Application by Morecambe Offshore Wind Limited for Morecambe Offshore Windfarm Generation Assets

The Examining Authority's additional written questions and requests for information (ExQ3)

Issued on 25 March 2025

7 Liverpool Bay SPA with 1.9nm CPP1 WTG and OSP Aviation Buffer and 2.4nm Calder WTG and OSP Buffer

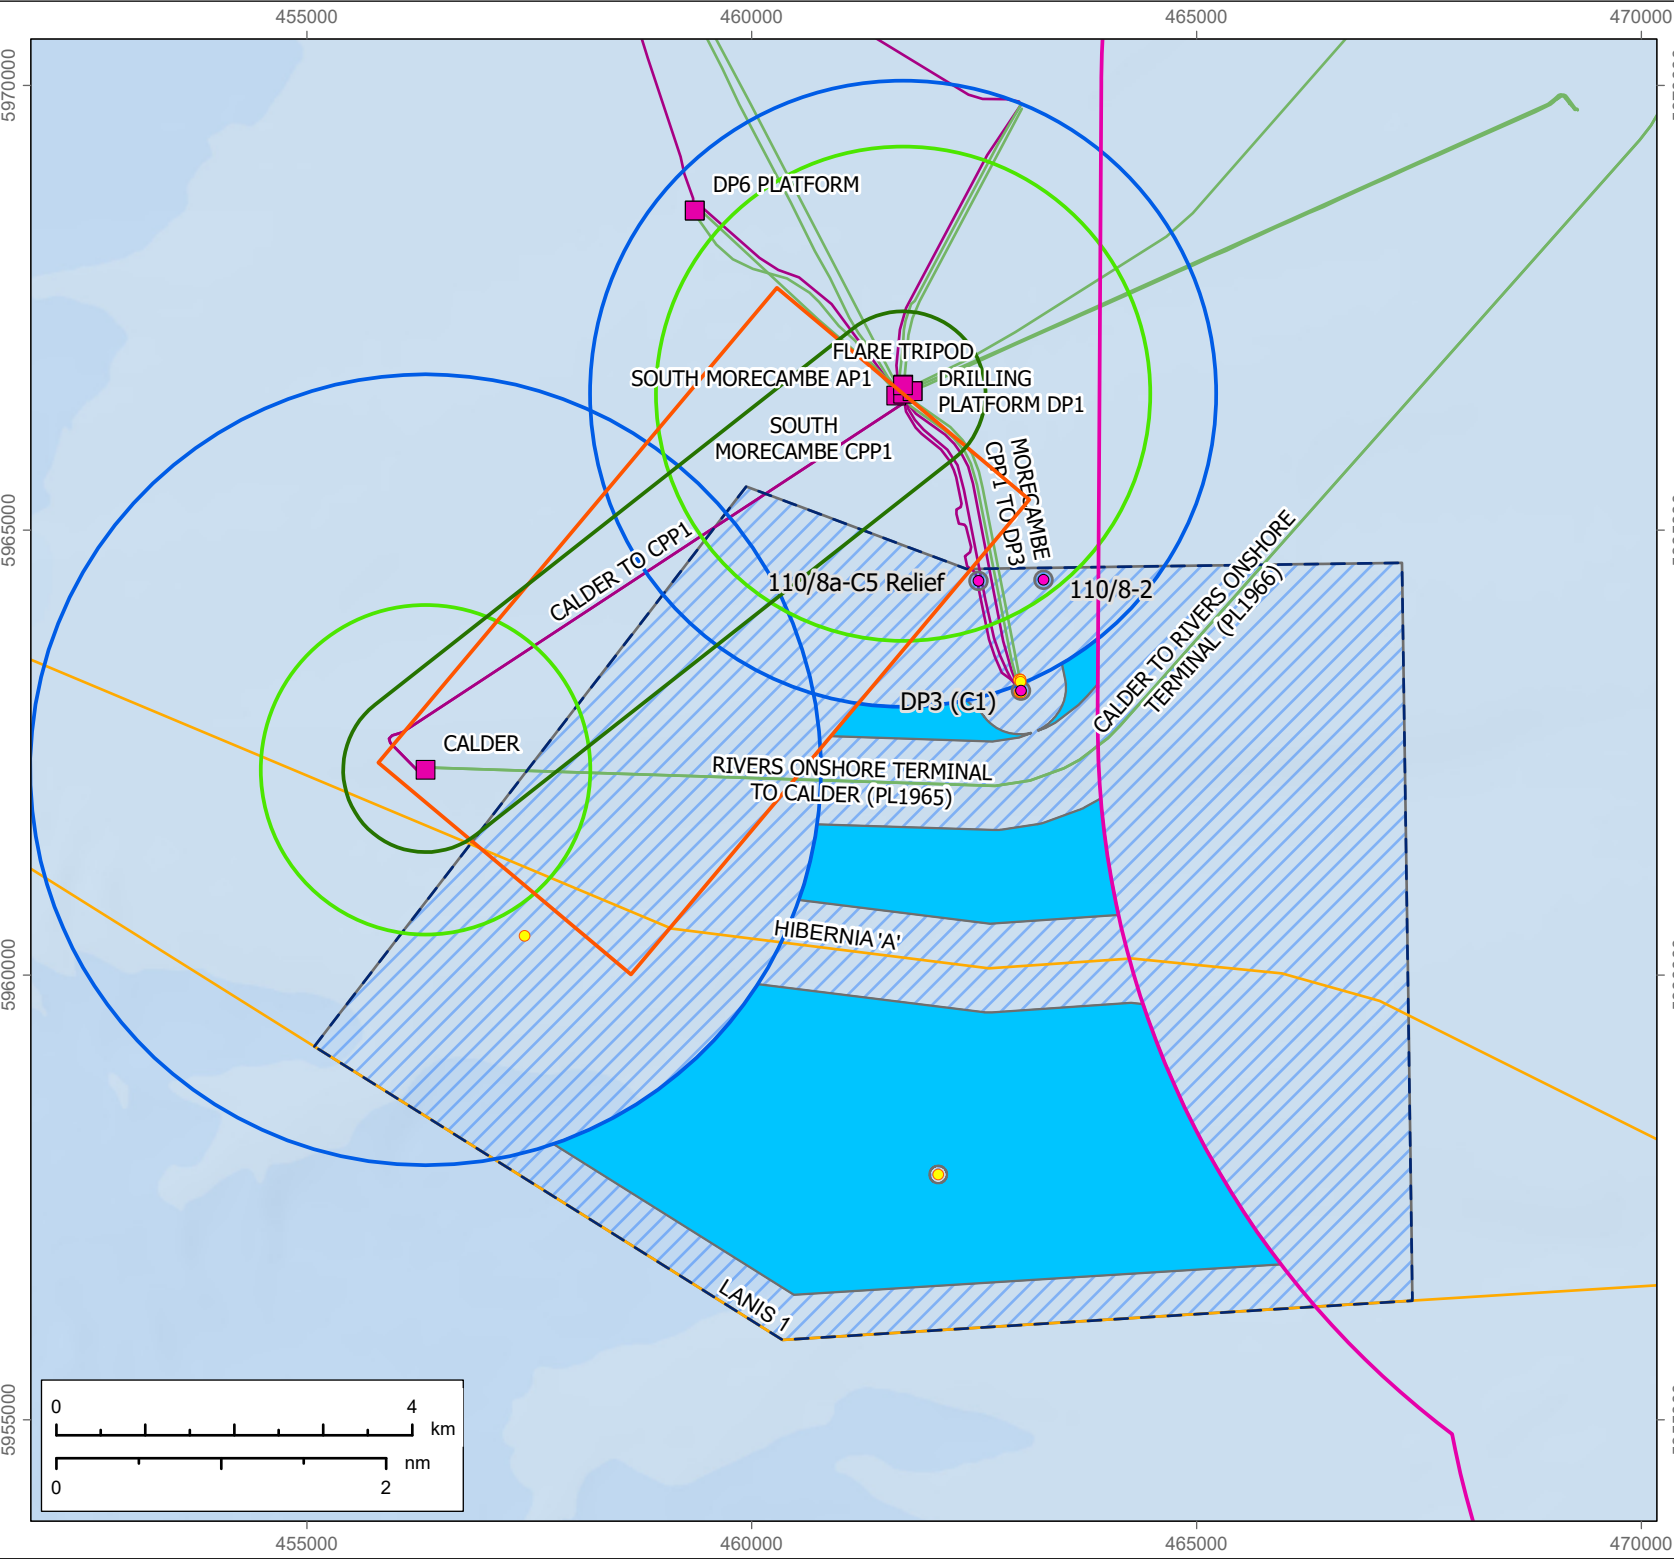
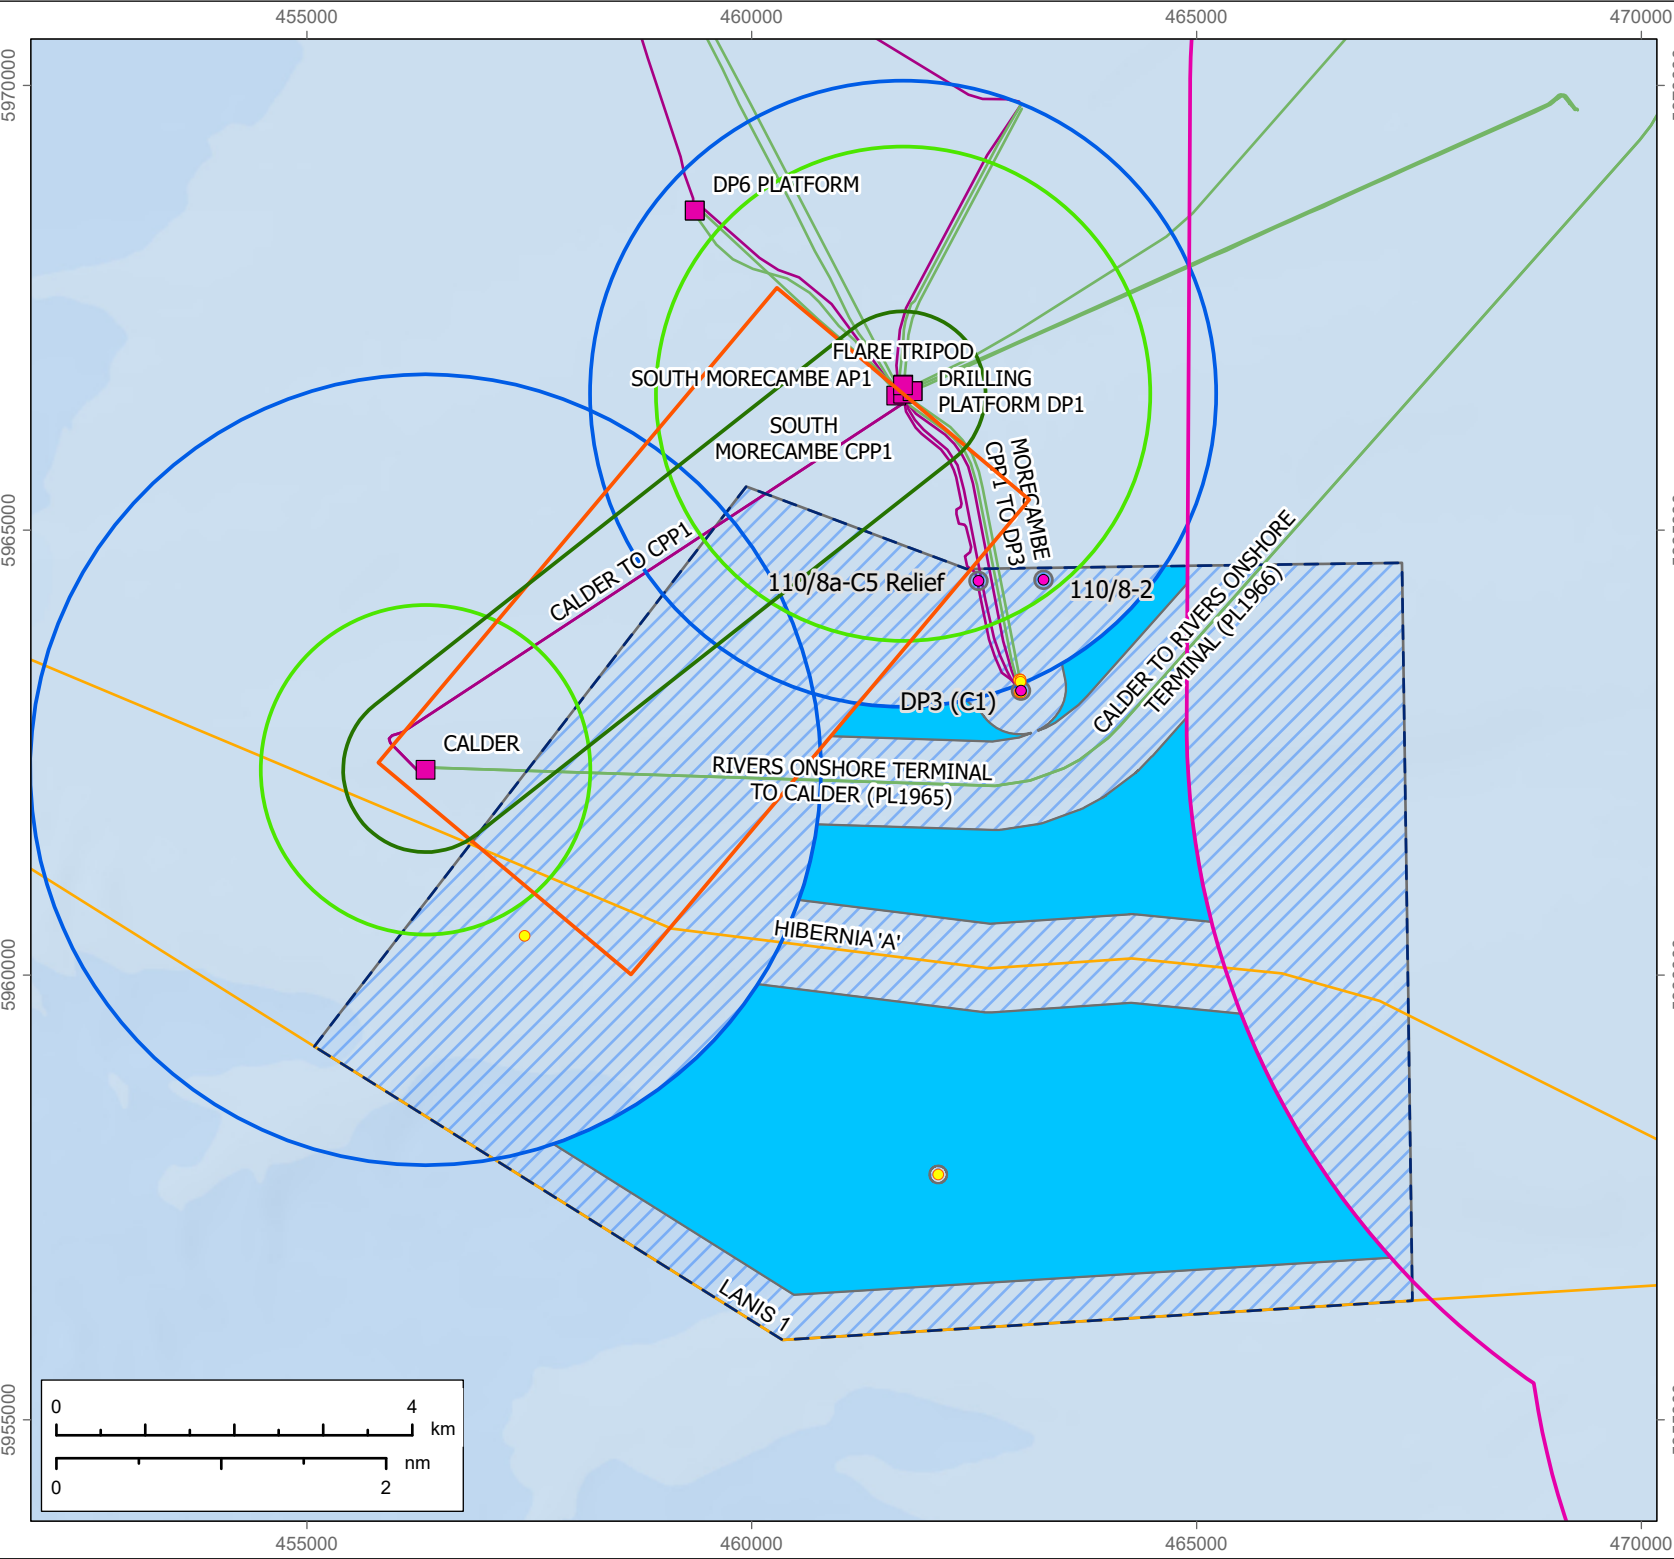
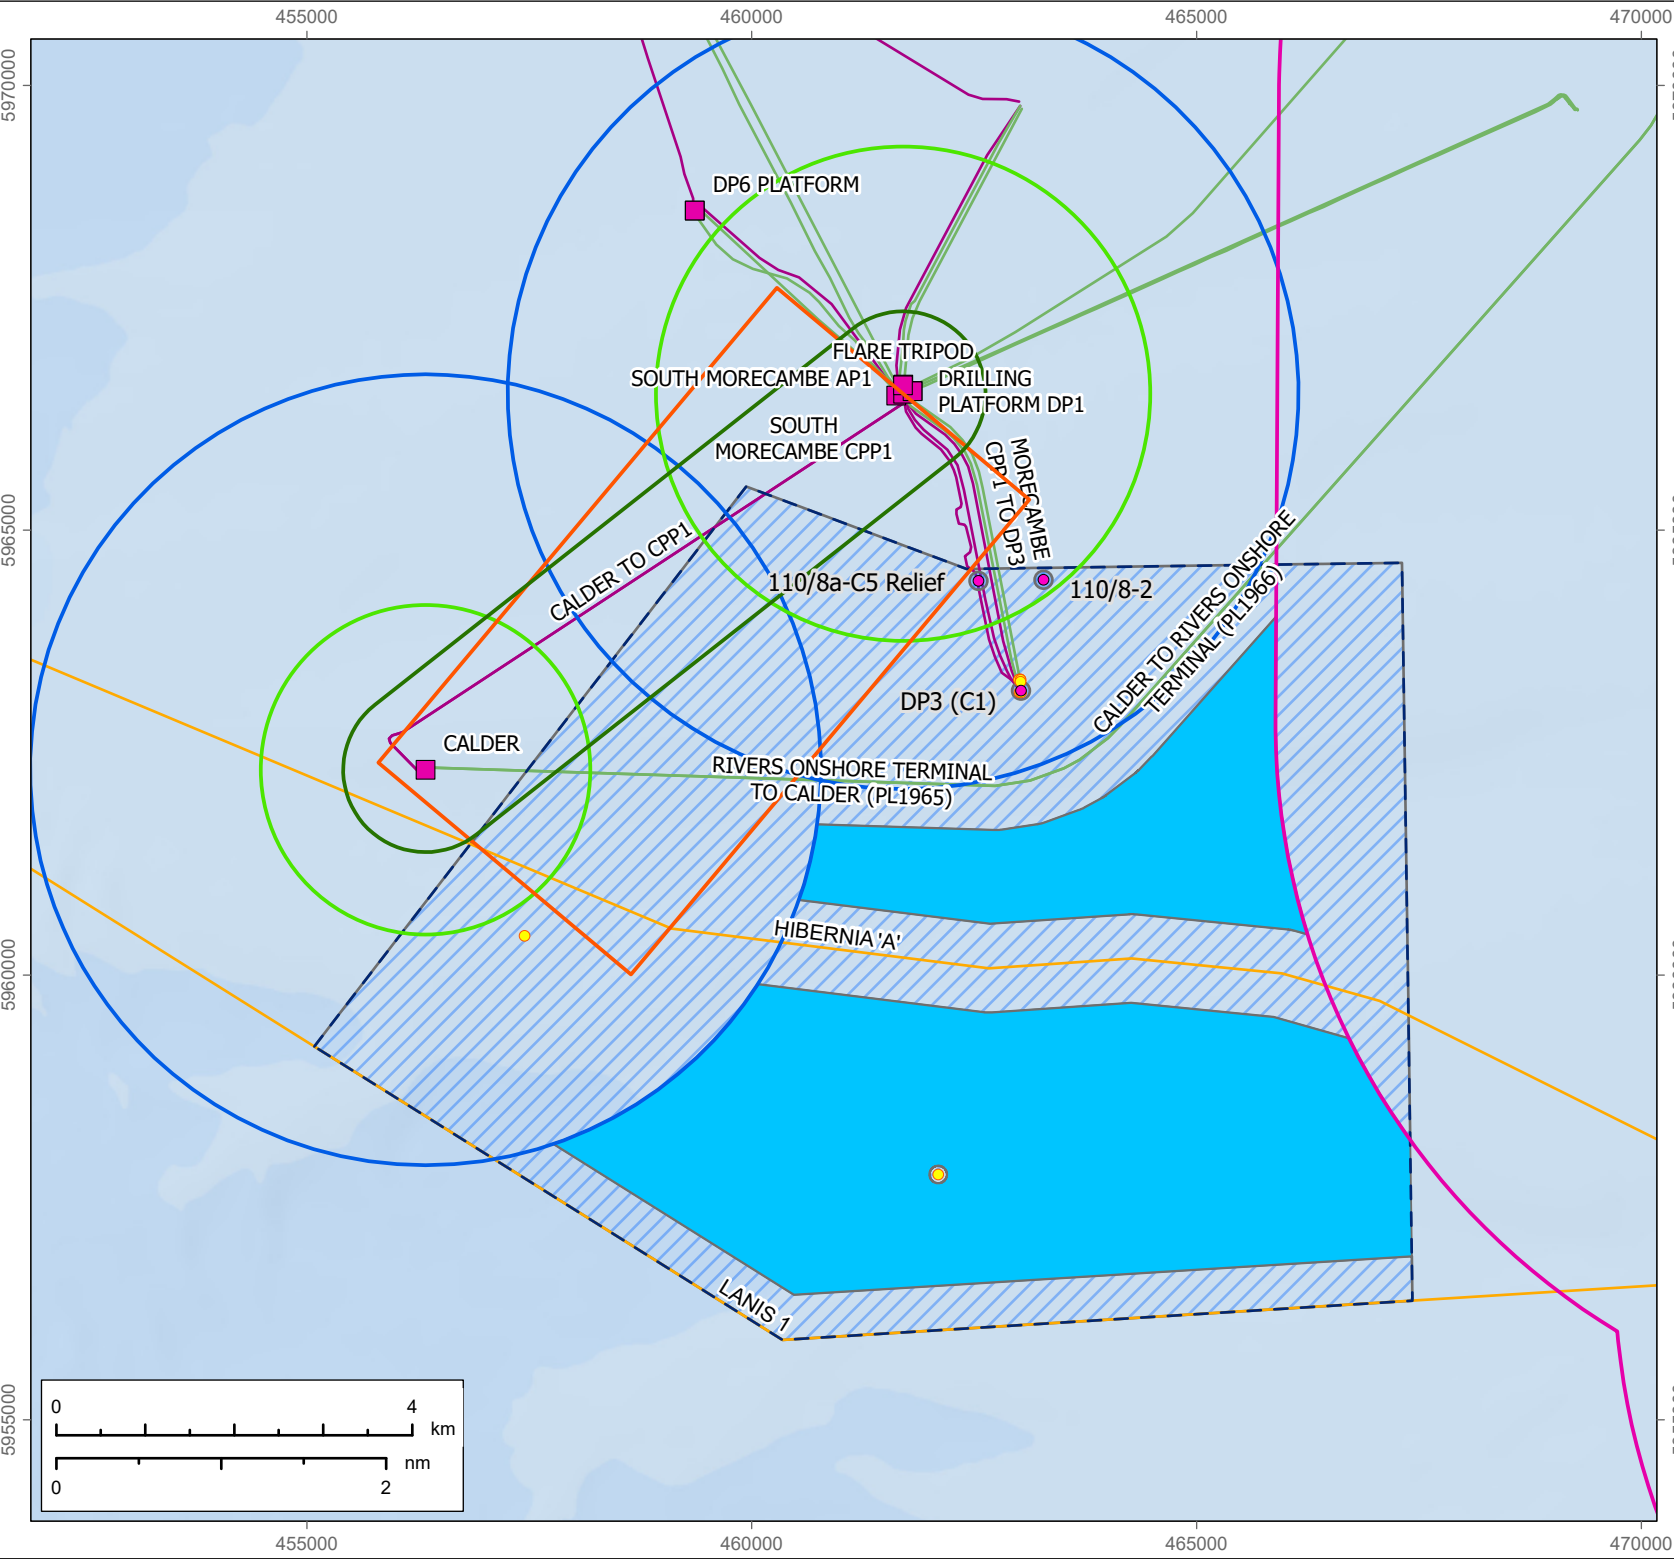
ExQ3	Question to:	Question:										
3GEN3.	The applicant	<p>Liverpool Bay SPA and Oil and Gas Platform Buffers</p> <p>Whilst the ExA notes the caveats stated in the applicant’s response to ExQ2HRA6 at D5 [REP5-070], to further demonstrate and support the applicant’s position:</p> <p>a) please can the applicant provide individual plans to demonstrate the impact that each of the incrementally smaller buffers from the original Liverpool Bay SPA would have on the layout and number of WTGs that could be accommodated within the site (i.e. 10km, 9km, 8km, 7km and so no buffer associated with the SPA affects the site) - with all other existing buffers/ corridors as shown on [REP5-007] unchanged.</p> <p>b) in Spirit Energy’s response to ExQ2CAR5 at D5 [REP5-090] it advises a buffer distance of 1.9nm is the minimum acceptable requirement for safe landing and take-off in daytime VMC and for night VMC this distance would be 2.4nm. In light of this could the applicant provide plans for each alternative SPA buffer scenario in (a) plus each of the increased buffer scenarios from the Calder and CCP1 platforms as set out in the following table.</p>

<table><tr><th><u>CPP1 WTG and OSP Aviation Buffer</u></th><th><u>Calder WTG and OSP Buffer</u></th></tr><tr><td>1.9nm</td><td>2.4nm</td></tr></table>

<p>c) any additional comments or further information the applicant wishes to provide on the implications of each of the above scenarios (noting the applicant’s previous response [REP5-070], EXQ2HRA3 and 2HRA6].</p> <p>The ExA is seeking a complete set of alternative scenarios shown on plans, so that, whatever the SoS may determine, if they felt it was appropriate they could include the relevant plan within any final DCO without having to revert to the applicant for that plan. Each should therefore have a different drawing number.</p>	<u>CPP1 WTG and OSP Aviation Buffer</u>	<u>Calder WTG and OSP Buffer</u>	1.9nm	1.9nm	2.4nm	1.9nm	1.9nm	2.4nm	2.4nm	2.4nm
<u>CPP1 WTG and OSP Aviation Buffer</u>	<u>Calder WTG and OSP Buffer</u>											
1.9nm	1.9nm											
2.4nm	1.9nm											
1.9nm	2.4nm											
2.4nm	2.4nm											
3GEN4.	The applicant	<p>Design Statement - Cabling</p> <p>Could the applicant please explain why (former) provision DC15 relating to use of the most direct/ efficient cabling route to minimise cutting has been deleted from the post-consent design code in Table 6.1 of the Design Statement [REP5-008] and [REP5-009].</p>
